Environmental Health Consultation Response		Officer	Michaela Gleave
<b>Detail: Change of Use from existing retail store (E Commercial) into a taxi office (Sui Generis).</b>			
<b>Address:</b>	<b>Unit 2 75 Berry Lane Longridge PR3 3WH</b>		 <b>Ribble Valley Borough Council</b> <a href="http://www.ribblevalley.gov.uk">www.ribblevalley.gov.uk</a>
<b>Application Ref:</b>	03/2021/0999	<b>Case Officer:</b> Adrian Dowd	
<b>Response Ref:</b>	46983/Y01	<b>Issue Date:</b> 18 <sup>th</sup> October 2021	
<b>General Comments/Observations</b>			
<b>1.1</b>	<p>Due to the close proximity of the proposed development to sensitive (residential) premises, there are concerns that it may have the potential to cause noise nuisance or anti-social behaviour to the occupiers of those premises during the evening/night-time, due to the increased number of people on the street, the congregation of people waiting for taxis, the noise of taxi engines idling on the street whilst waiting for occupiers to get in/leave and the slamming of vehicle doors. I would recommend the following before I can provide full comments on this application:</p>

<b>Officer:</b>	<b>Michaela Gleave</b>

Proposed Site / Ground Floor Layout
1 : 50

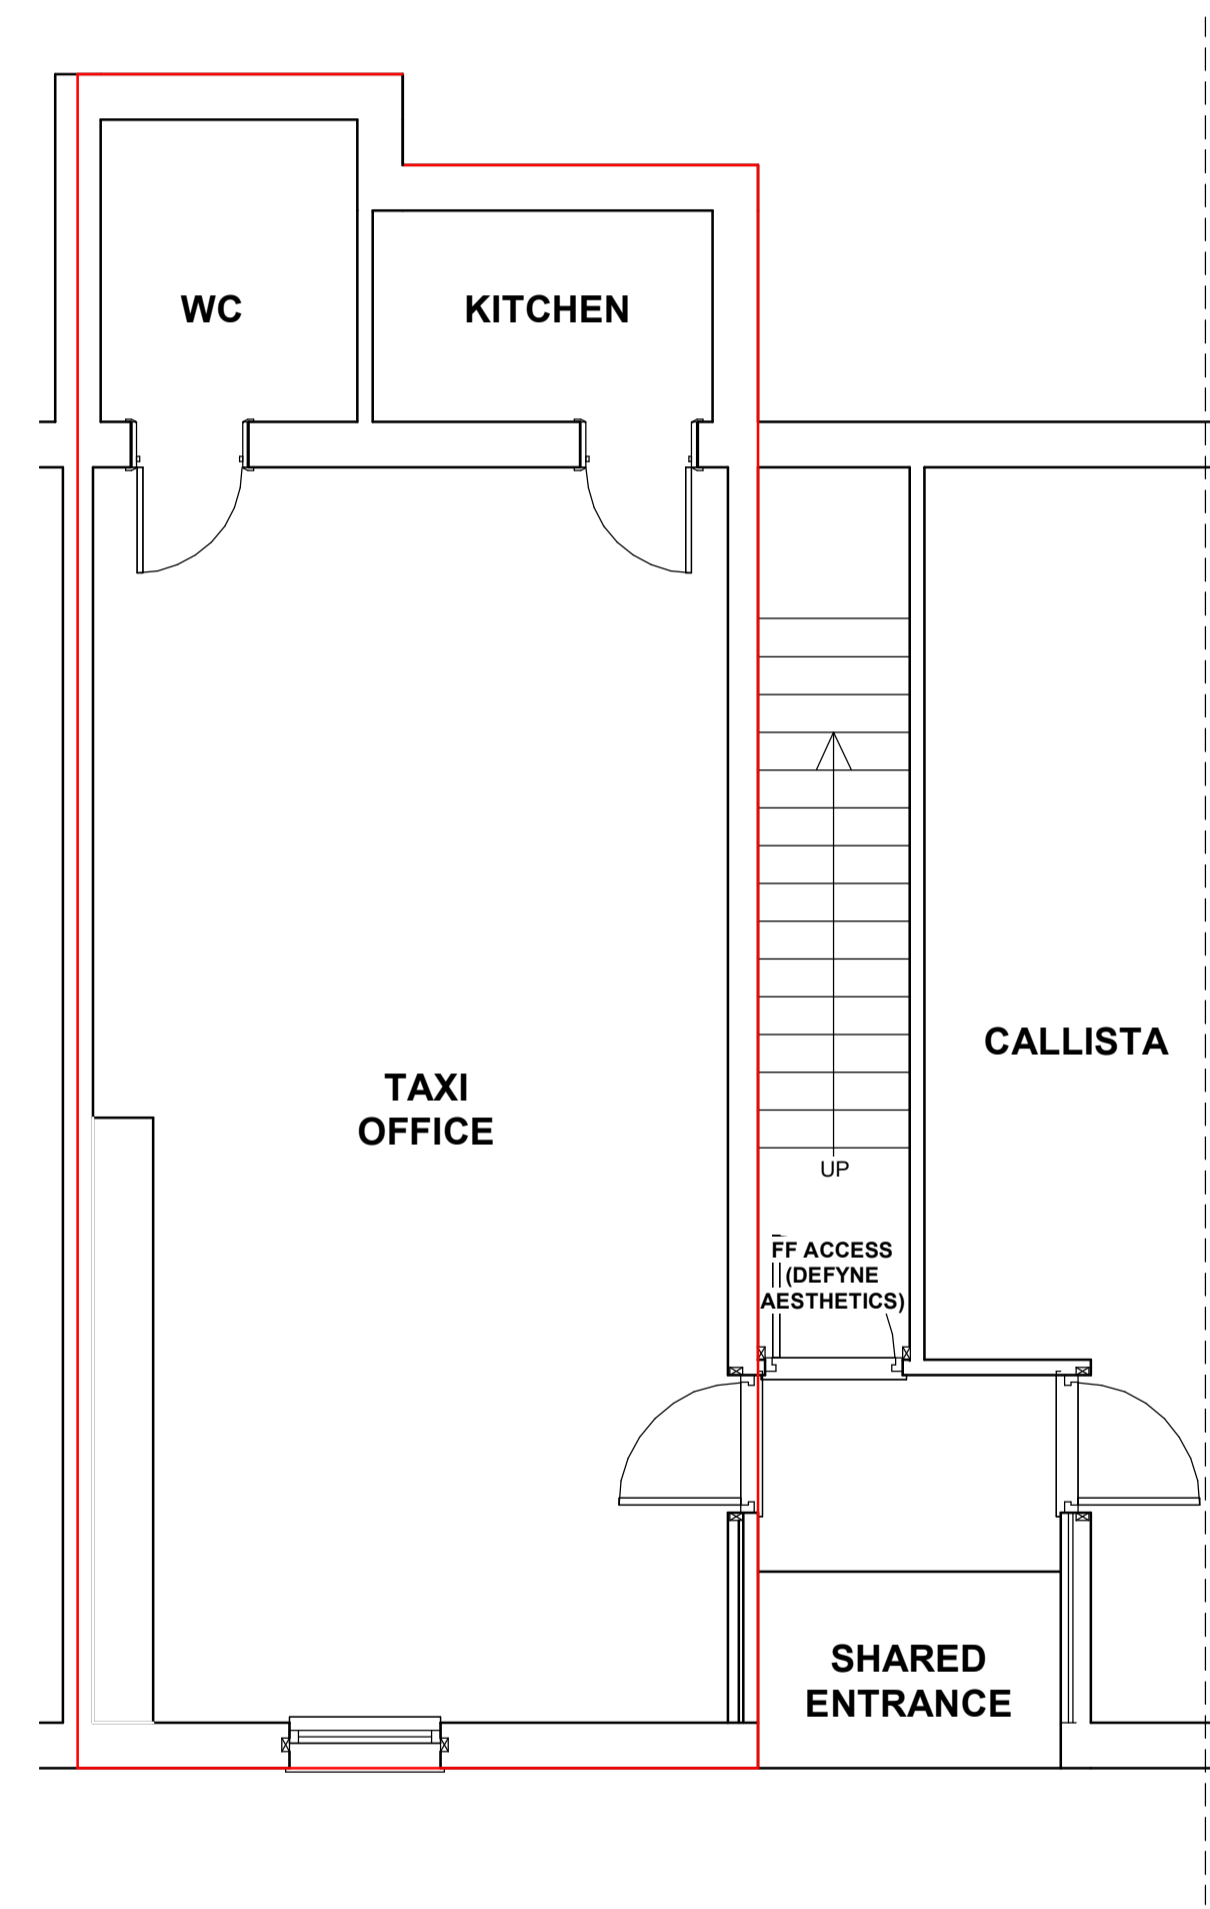
<b>Conclusions/Suggested Conditions</b>			
<b>2.1</b>	<p><b>NOISE</b></p> <p>A noise assessment and noise management plan should be undertaken by a competent authority to show that the proposed development would meet the following requirements. The level of noise created by use of the proposed development must not exceed the following levels, as assessed in accordance with British Standard 8233 (2014) and WHO guidelines (or any subsequent replacement national standards / guidance) when measured at the nearest noise-sensitive premises:</p> <p>LAeq 50 dB 16 hours – gardens and outside living areas, daytime (07.00-23.00)  LAeq 35 dB 16 hours – indoors, daytime (07.00-23.00)  LAeq 30 dB 8 hours – indoors, night-time (23.00-07.00)  LAFmax 45 dB 8 hours – indoors night-time (23.00-07.00)  LAFmax 45 dB 4 hours – indoors evening (19.00-23.00)*  LAFmax 60 dB 8 hours - façade level night time (23.00-07.00)  LAFmax 60 dB 4 hours - façade level evening (19.00-23.00)</p> <p>*The evening standard LAFmax will only apply where the evening LAFmax significantly exceeds the LAeq and the maximum levels reached are regular in occurrence, for example several times per hour.</p>
